Scott Meredith
Tri-State Generation and Transmission Association
1100 W. 116th Ave.
Denver, CO 80233

June 19, 2024

This memo is to serve as an addendum to the original Vollmer Substation drainage report prepared by Terra Nova, dated January 31, 2022. This memo summarizes the design of a new extended detention basin to replace the existing sand filter and demonstrate compliance with El Paso County design requirements.

CONCRETE OUTLET STRUCTURE
FRONT VIEW
N.T.S.

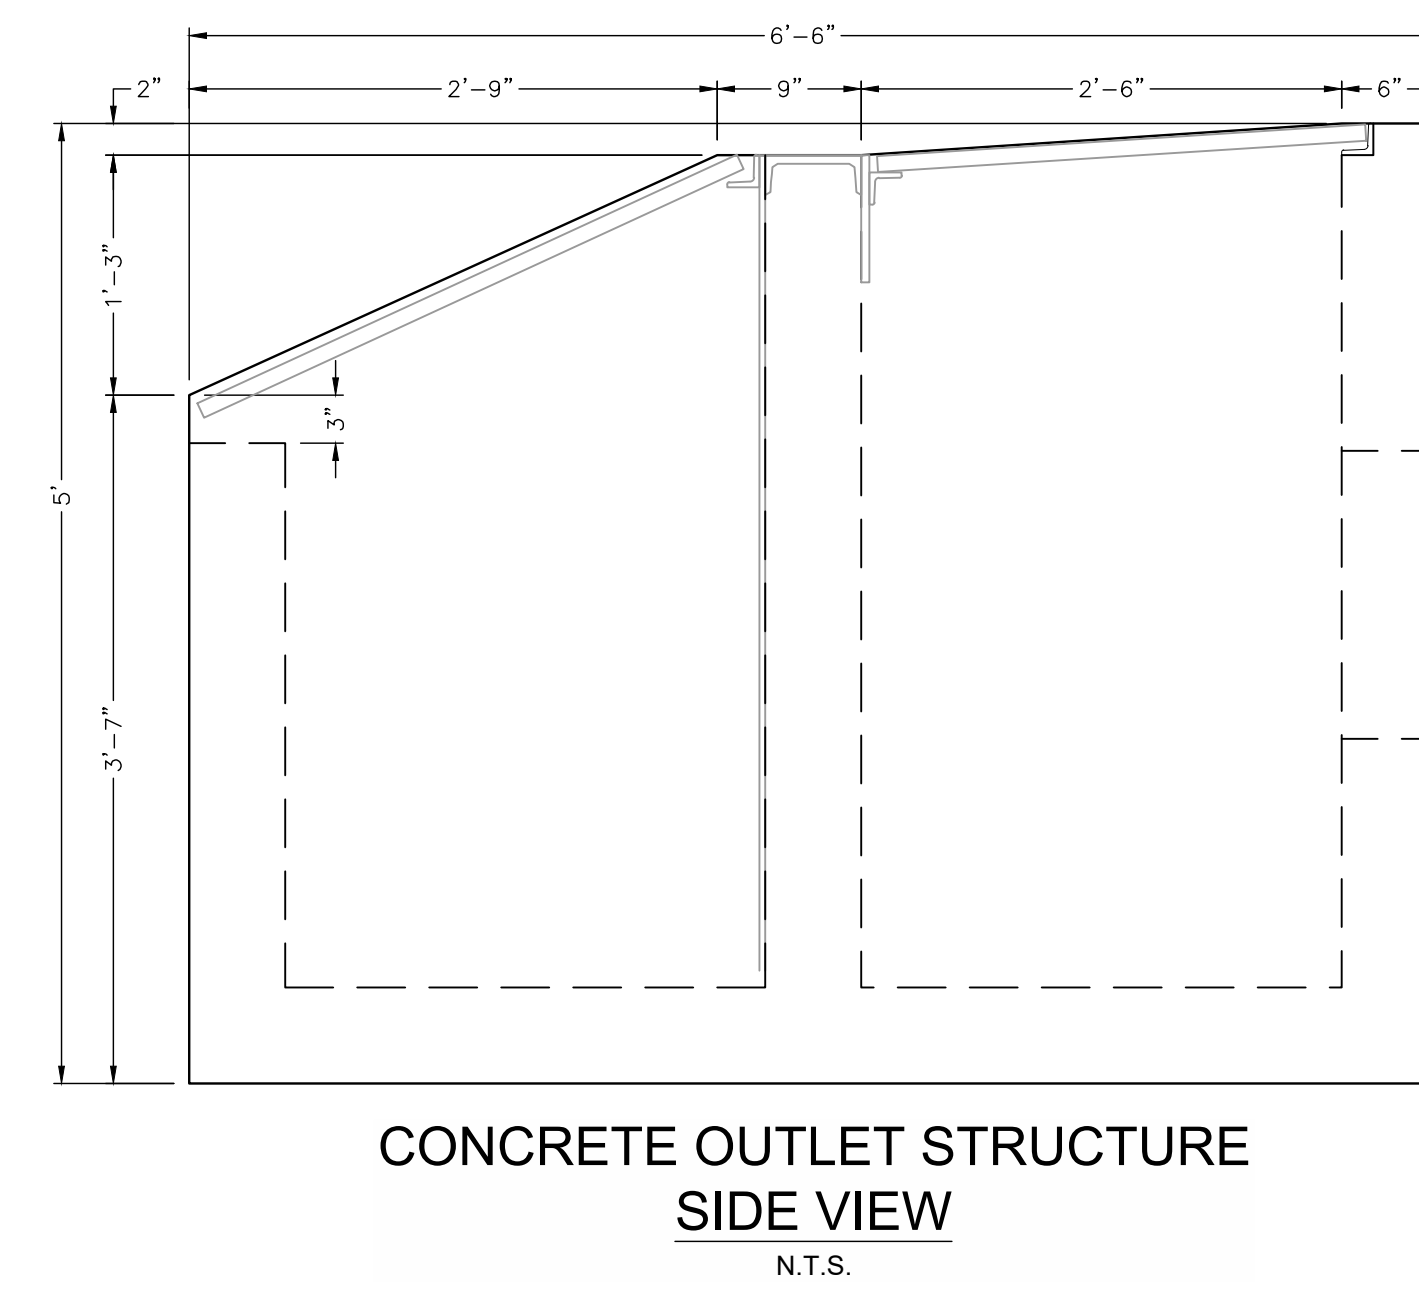
A spillway is necessary, please input values here and see my comment on the CDs
